Proposal: Approval of details reserved by condition imposed under ref R/187/16/PL relating to Condition Nos 13 - provision to prevent surface water discharging to public highway, 19 - foul and surface water sewerage disposal, 20 - surface water drainage and 22 - maintenance and management of SuDs system.

Site: R/53/22/DOC: - Rustington Convalescent Home, Sea Road, Rustington, BN16 2LZ.

Southern Water cannot recommend discharge of condition 19 relating to foul disposal.

11659/1902

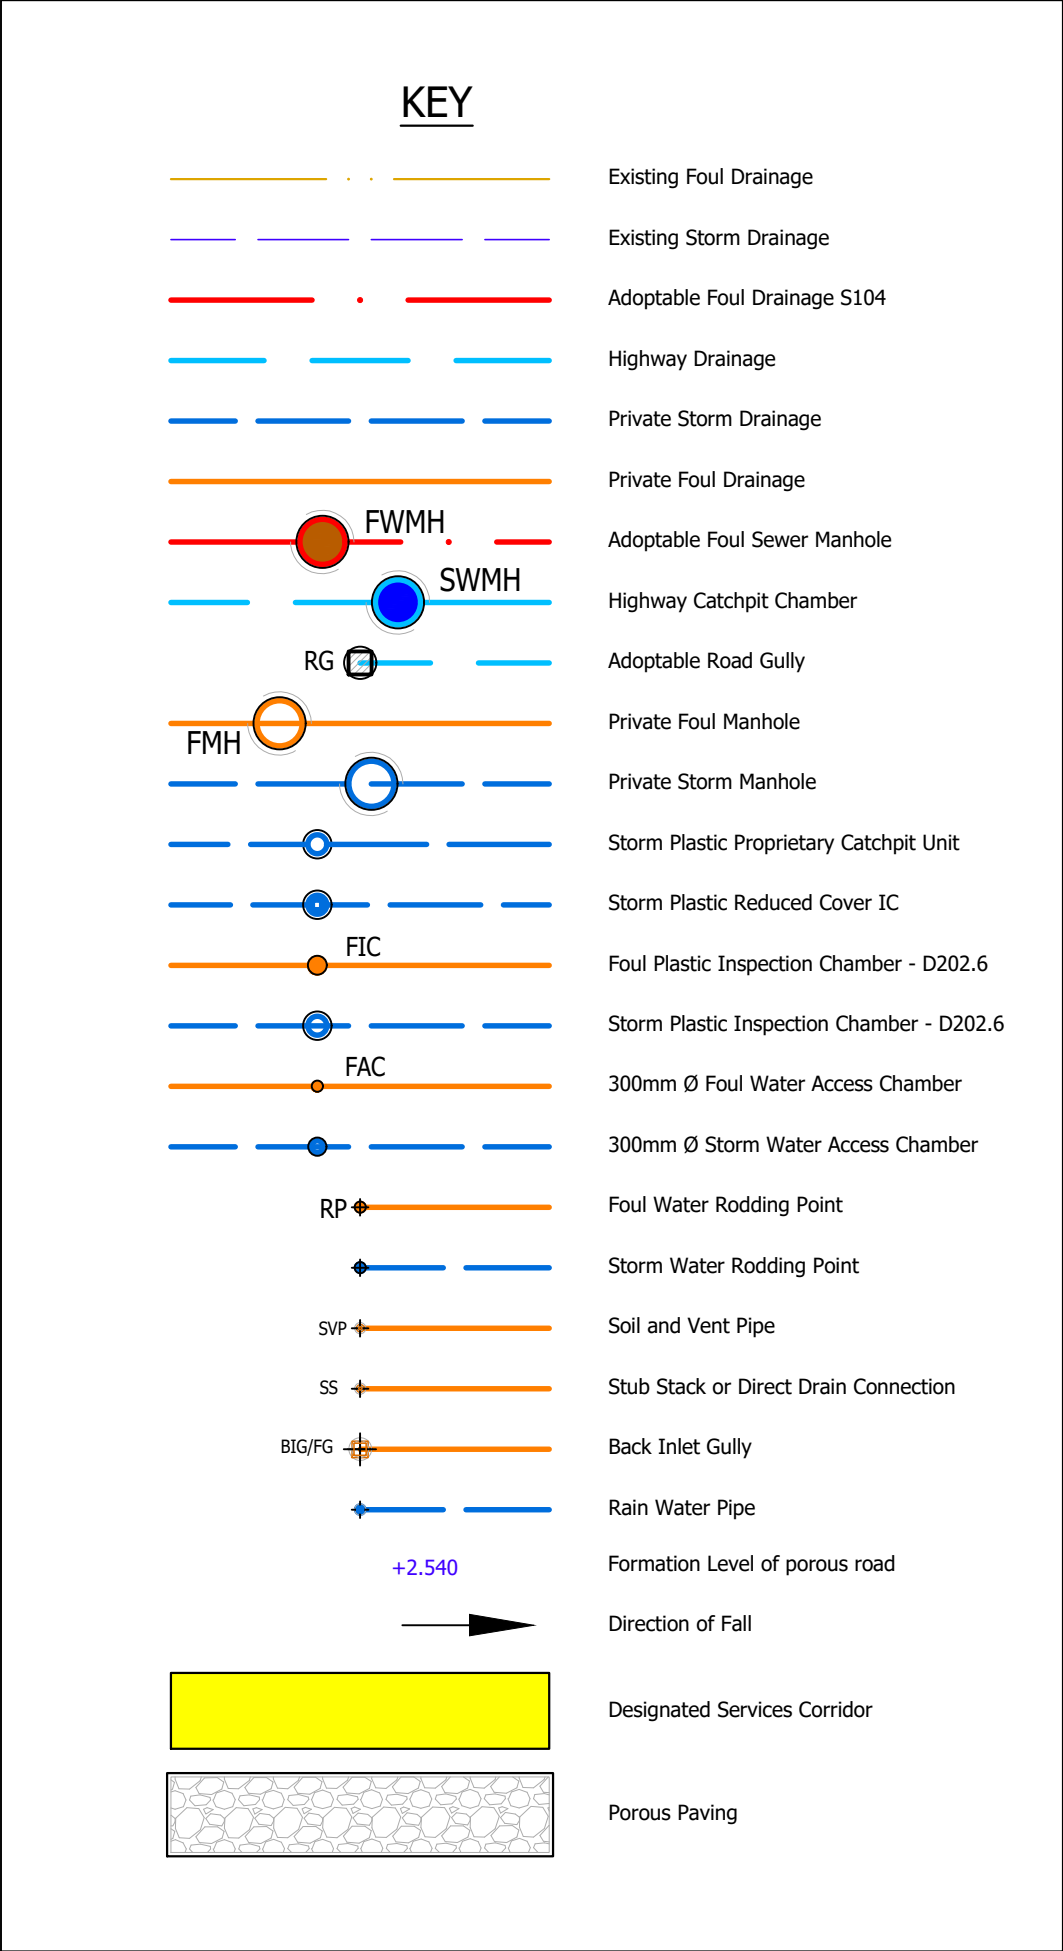
It appears that the applicant is proposing to abandon a sewer which is not shown in our records. If found to be public, the sewer on the site needs to be diverted/abounded. Southern Water requests a formal application for sewer diversion under S185 of Water Industry Act 1991 in order to divert any public sewer. An application should be made using Southern Water's Get Connected Service at: developerservices.southernwater.co.uk
